THE PADDINGTON SOCIETY INC
FOR COMMUNITY AND HERITAGE
EST 1964

OBJECTIONS including 5 Appendices

15 March 2026

TO 142-148, 160 OXFORD ST, 13 GIPPS ST, 6 SHADFORTH ST
STATE SIGNIFICANT DEVELOPMENT SSD 97528708

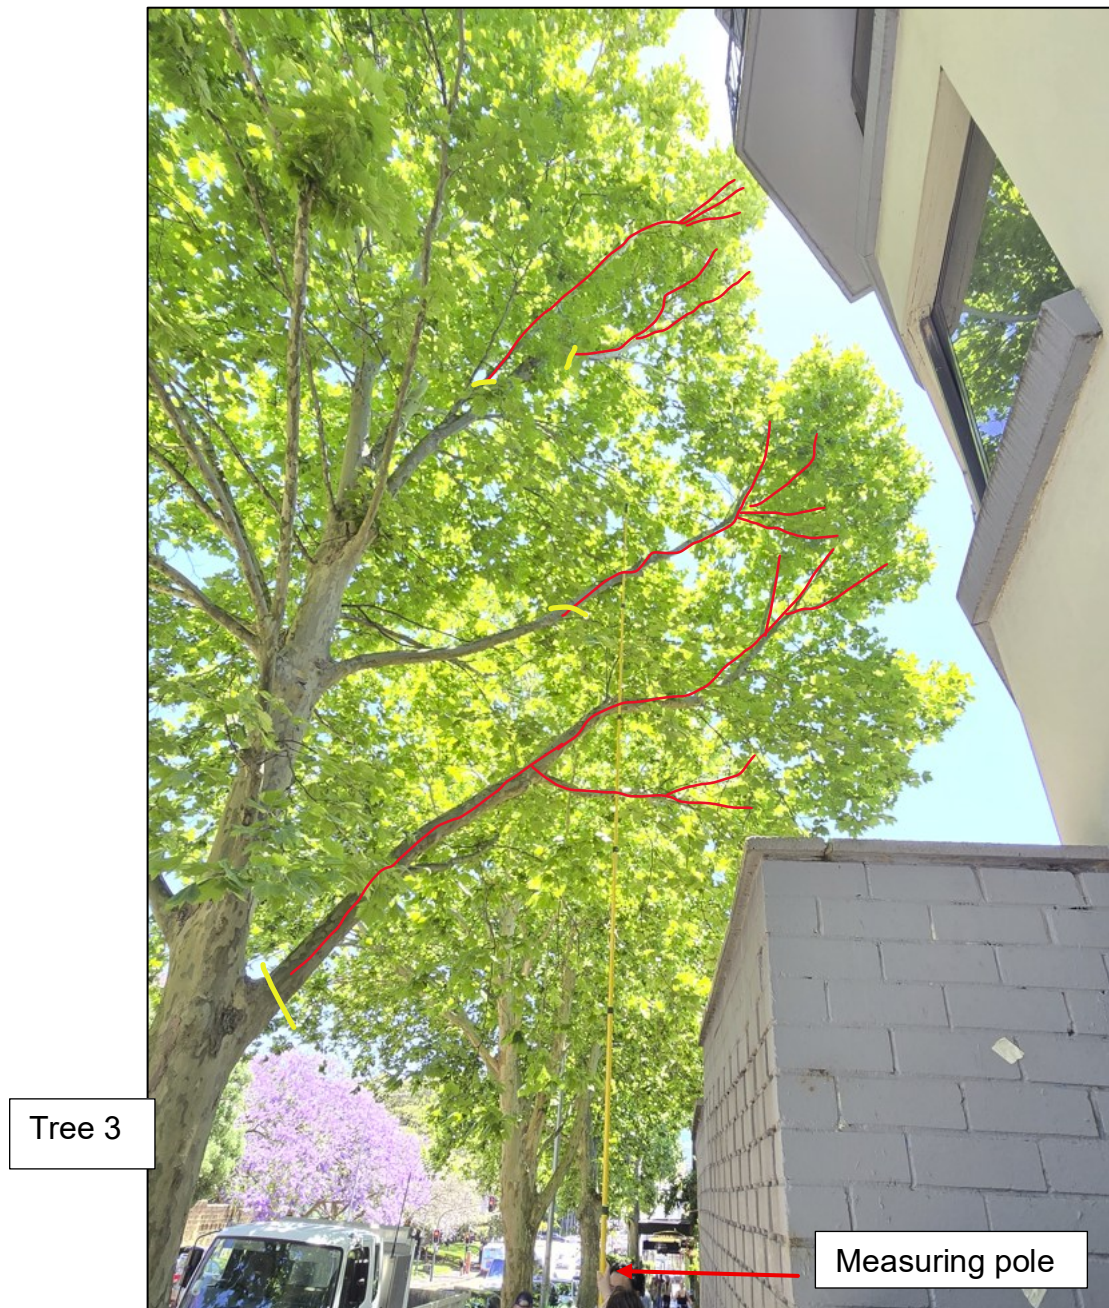
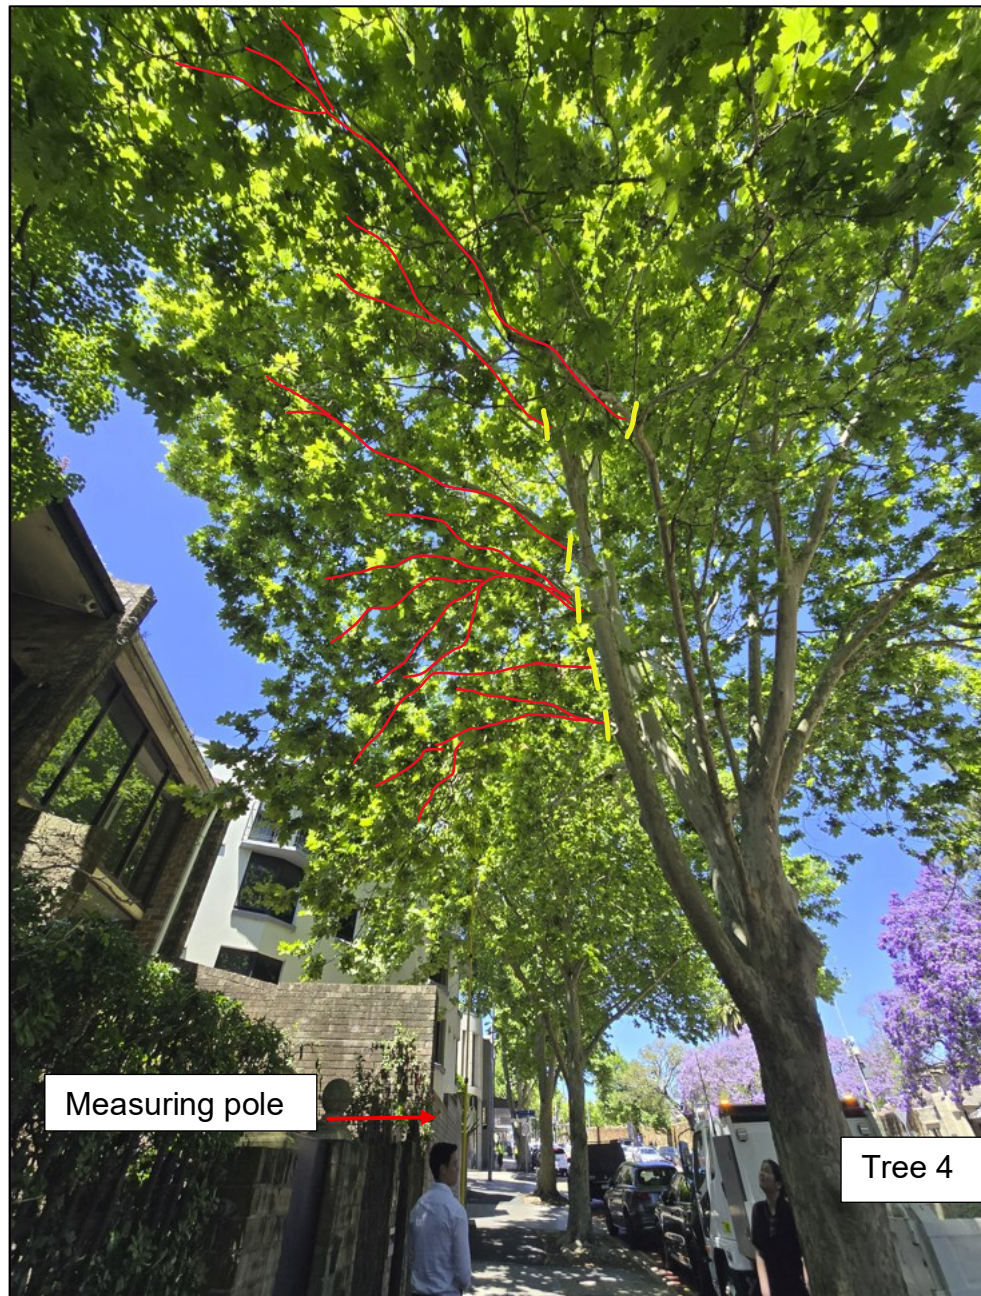
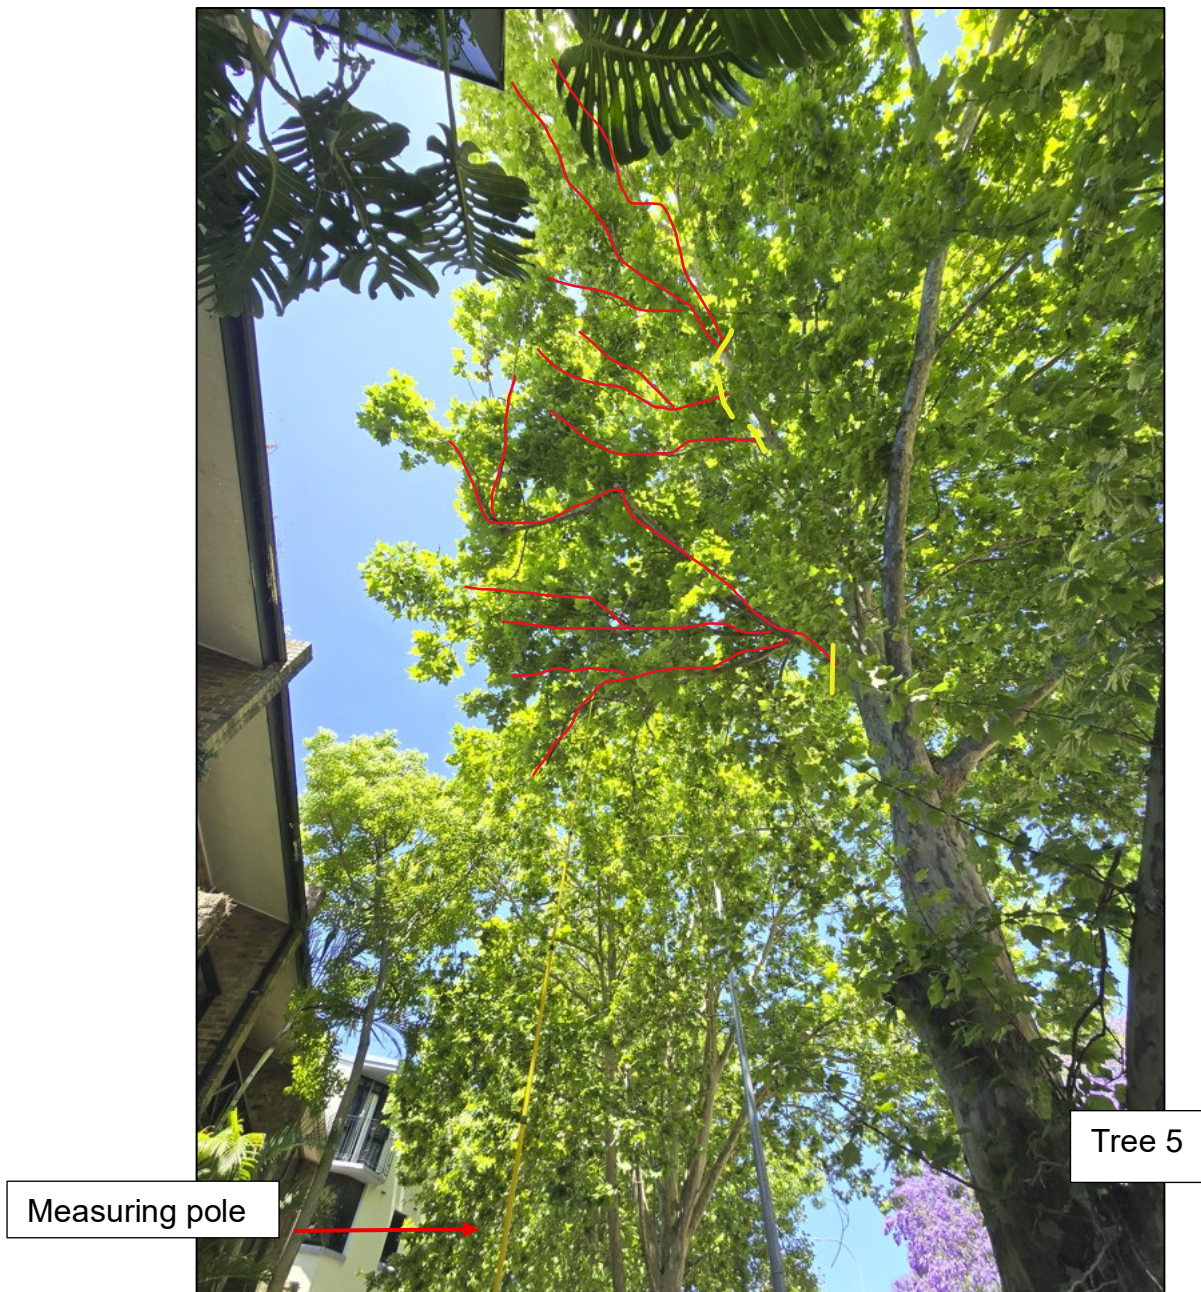
The proposed development will impact the health of this row of trees. For example, the first 5 storeys of the building are effectively on the Oxford St site boundary and are proposed to have significant alteration to the branches from TO2 – TO5. This will alter the form of the trees markedly. (Criterion 1 for High Significance)

Figure 4.5
Overshadowing diagram showing the impact at 9am on 21 June
Source: Smart Design Studio

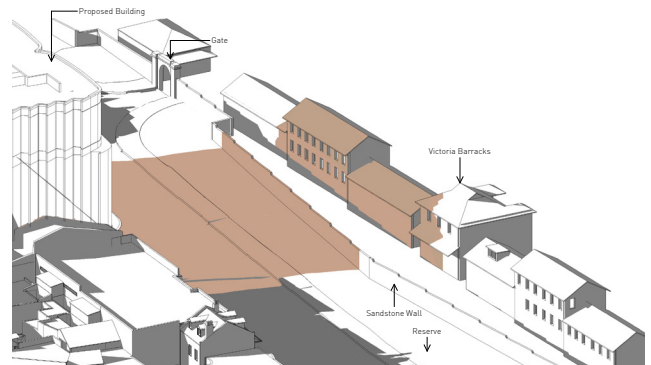
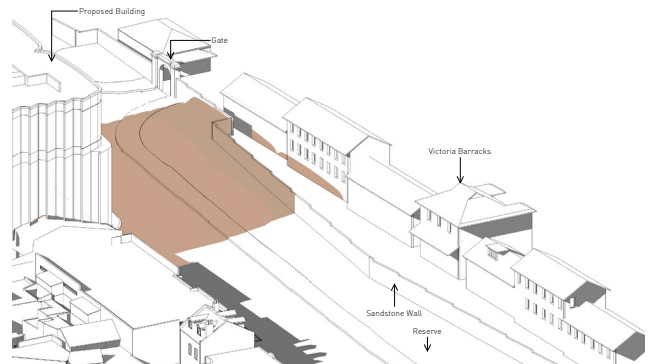
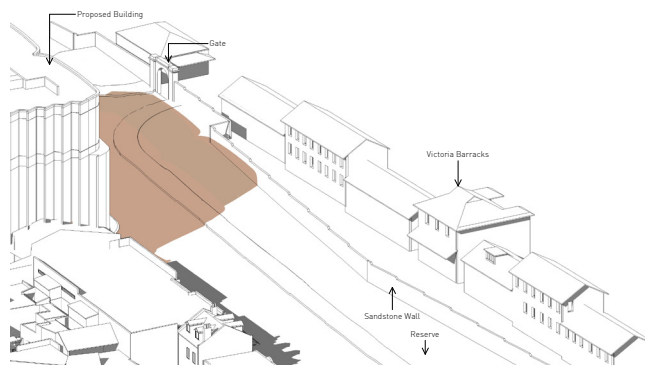
- Winter **solar access** from 9am to noon will be lost to Oxford St Reserve and the walls to Victoria Barracks – thus diminishing the Barracks’ heritage significance and the public’s enjoyment of the Reserve, a popular seating spot in winter.
- **Traffic:** the movement of 83 cars in and out of the proposed units into narrow Shadforth St (12 houses) will cause a large upswing in noise, lights, and congestion which will reduce the livability for the current residents. In addition, the applicant advises that construction trucks (30/day for 26+ months) will need to access the site via narrow Glenmore Rd, Liverpool and Shadforth Streets– causing intense congestion to an extensive area of the HCA, including “The Intersection” retail.
- We ask that this and other objections can be raised in a **Public Hearing** in front of the Independent Planning Commission, to allow the community a voice.

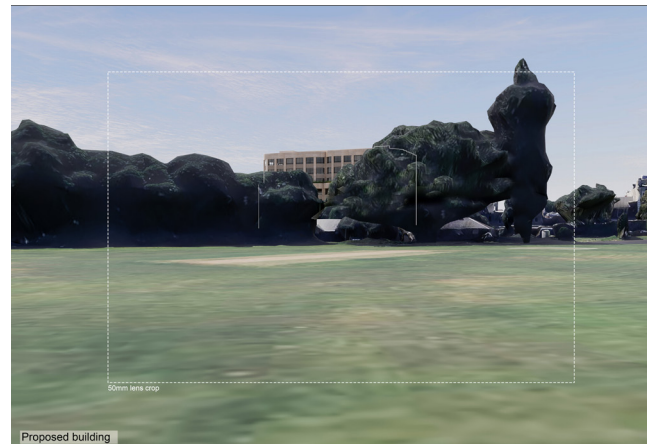
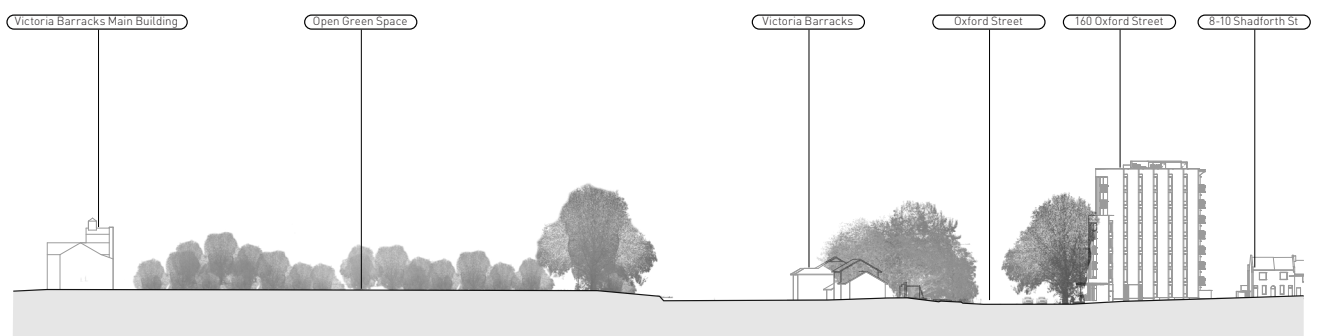
Figure 4.9 above from GBA EPBC Self Assessment shows visual impact of proposal from Main Barracks building: upper 2-3 storeys will be visible and will dominate the Parade Ground, an area of exceptional heritage significance. The Proposal will be much more prominent in winter due to deciduous trees – see above image to right
